Our ref: DOC19/10190978

Notice of Exhibition of application for (Glendell Continued Operations Project) (SSD 9349)

Katrina Stankowski
Senior Team Leader, Regional Heritage Assessments North
Heritage NSW
Department of Premier and Cabinet
As Delegate of the Heritage Council of NSW
11 February 2020

Figure 15: 100m Homestead Mine Around Final Landform Concept

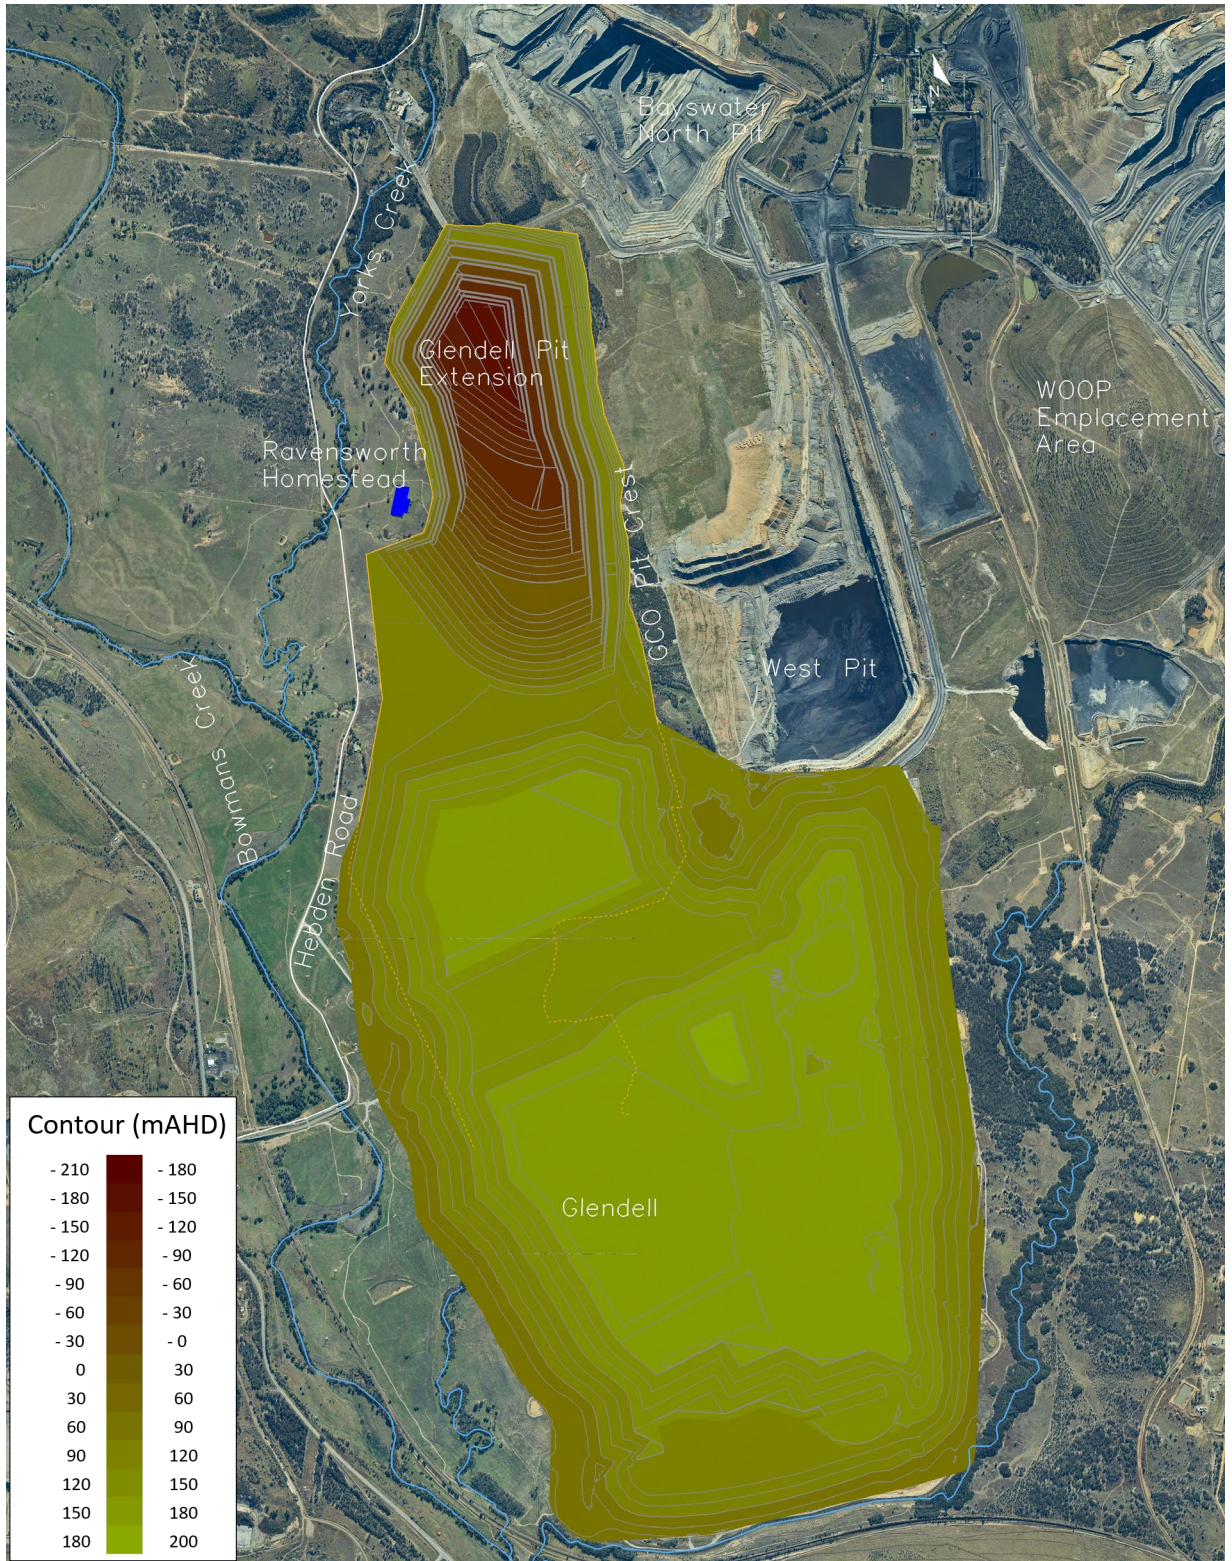
- The EIS has not adequately met the requirements of this SEAR as it has not provided an analysis of all reasonable and feasible options to preserve the Homestead (including leaving in situ) or an adequate justification of why Options 6, 7 and 8 are not possible to ensure that Ravensworth Homestead is not impacted by the proposed works.

Figure 20: Ravensworth Farm

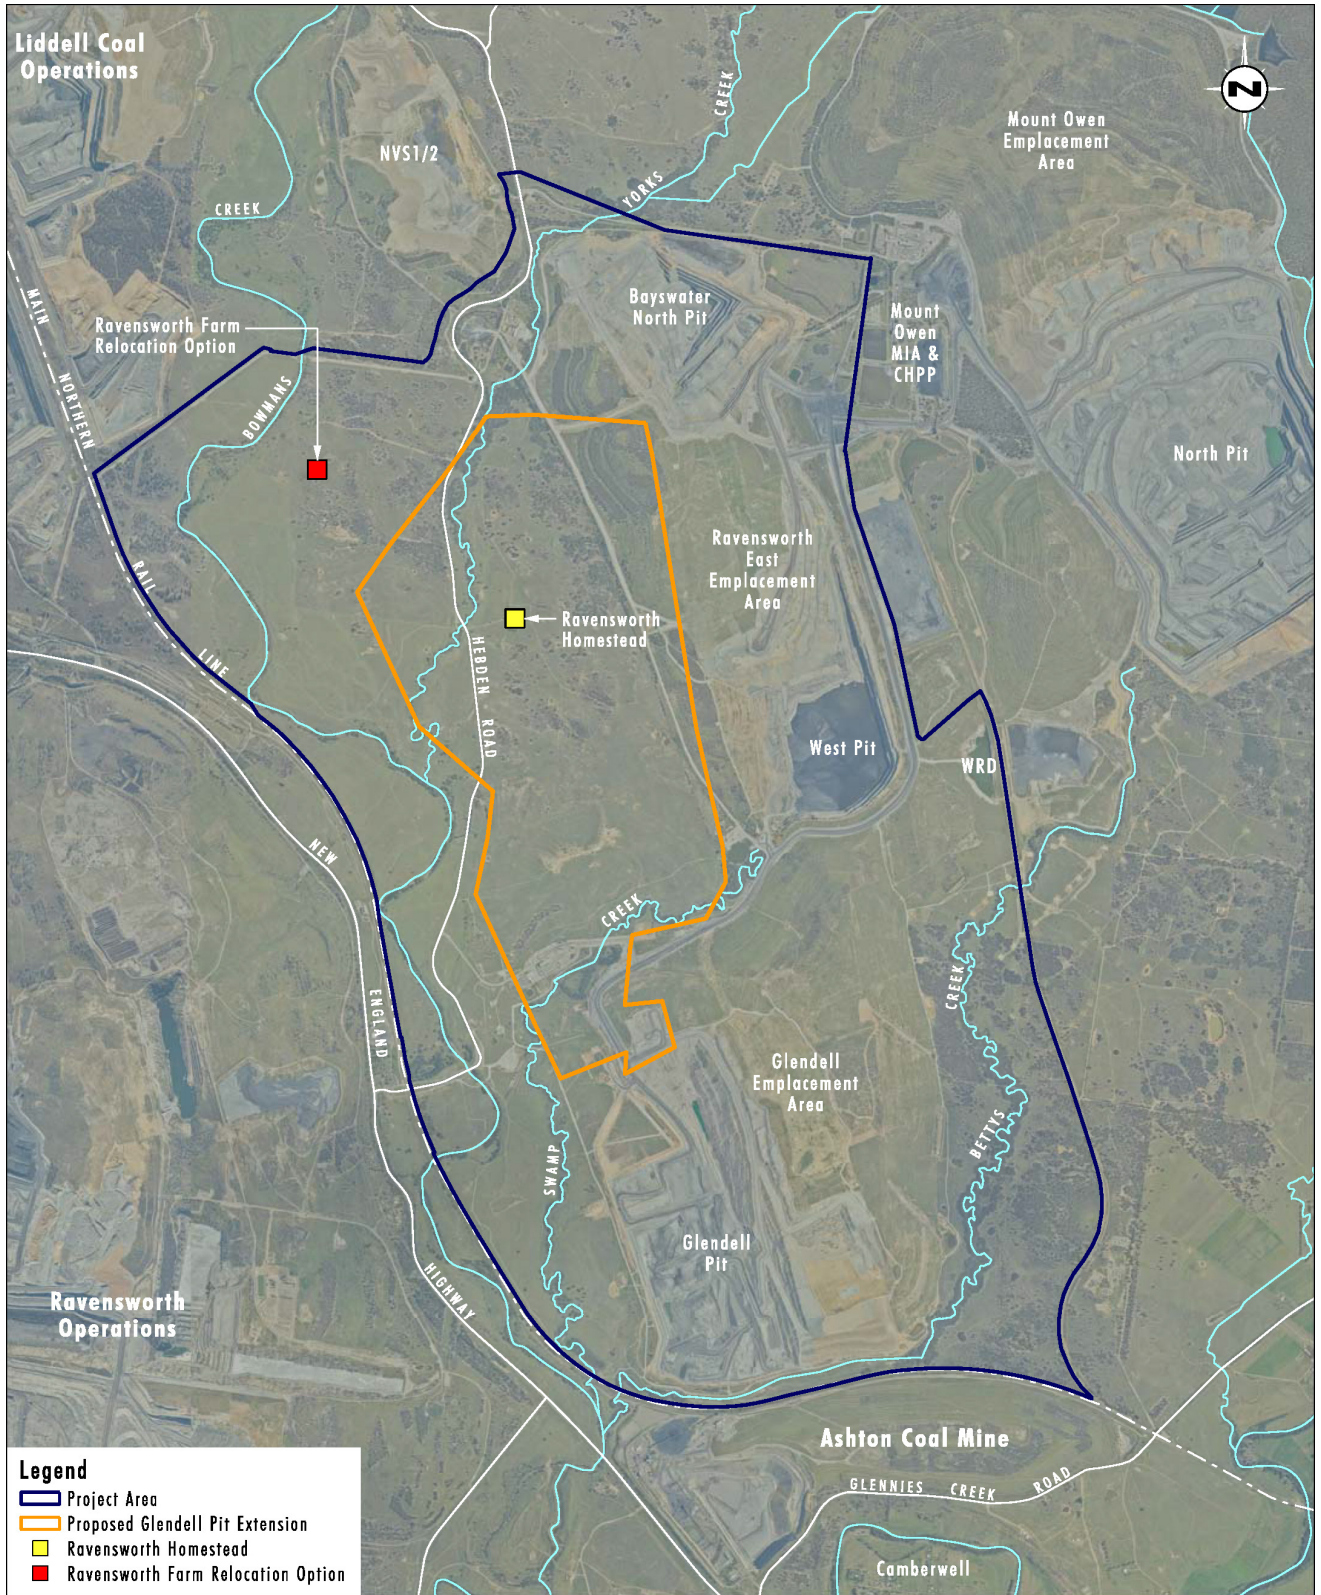
- There are several significant issues raised regarding the 'intact' relocation Option 1, including the unique project risks outlined by the movers, as well as the outstanding methodology and cost calculations that provide little certainty to this option.

- Insufficient information has been provided for Option 1 regarding the presence of underground mining under the recipient site and the likely blasting vibrations impacts on the relocated structures from existing adjacent mines.
- Similar issues exist for Option 2. The proposed removal of internal walls will remove original fabric, graded high significance and alter the internal layout, graded exceptional significance. The current Option 2 proposed approach to the conservation of Ravensworth Homestead including the similar approach to the outbuildings will have a severely detrimental impact to their heritage significance
